City of Albuquerque Stormwater Construction Site Inspection Report

ESC File No.	F16E011	Project Name:	NM JATC Building Addition		
NPDES Id. No.	NMR1002ZB	Location:	4501 Montbel Pl. NE		
5/20/2021	Owner	Contractor			
Operator	NM JATC for the Electrical Industry		Summit Construction		
Contact name & title	Charles Humiston		Ed Fuller		
e-mail	director@nmjatc.org		ed@summitconstr.com		
Contact Phone #	505-341-4444		505-239-4824		
COA Inspector	Thomas Evans		Start/End Time:	2:45 PM/3:05 PM	
Construction Phase:	Final Stabilization				
Type of Inspection:	Regular	Storm Event	Past Storm Event >0.25"	311/Complaint	Follow Up
Weather at time of inspection?	clear		Temperature:	~ 86	
Estimated date of last storm 0.25" or greater	5/3/2021

JATC 4501 MONTBEL	DRAWN MDT
	EROSION AND SEDIMENT CONTROL PLAN	DATE 5-7-20
	888-712-5120 PO BOX 400 LOS LUNAS NM 87031	SHEET # ESC 101

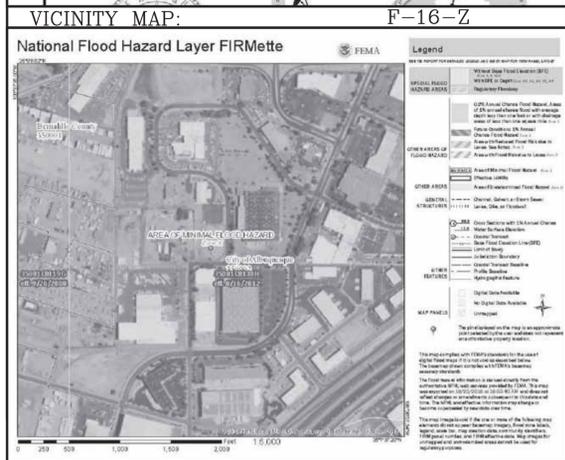
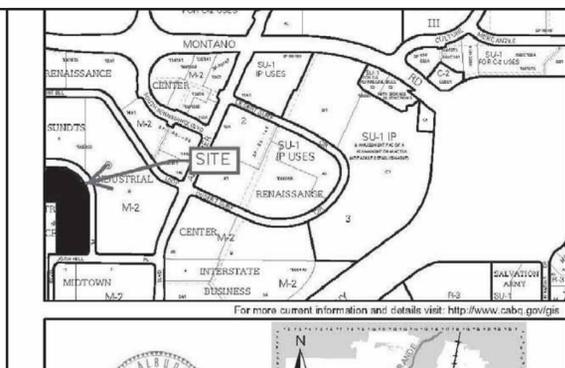
Item Number	Deficiency/ Corrective Action				
1	No posting of NOI. Re-post signage of NOI permit coverage in a location clearly visible to the public.				
2	Re-establish permitter BMPs for erosion and sediment control.				
3					
4					
5

Notes:	Per Ed Fuller, hydro-seed was applied 3 weeks ago across the site. Hydro-mulch was applied today. They removed their posting of permit coverage, and I directed them to re-post it.
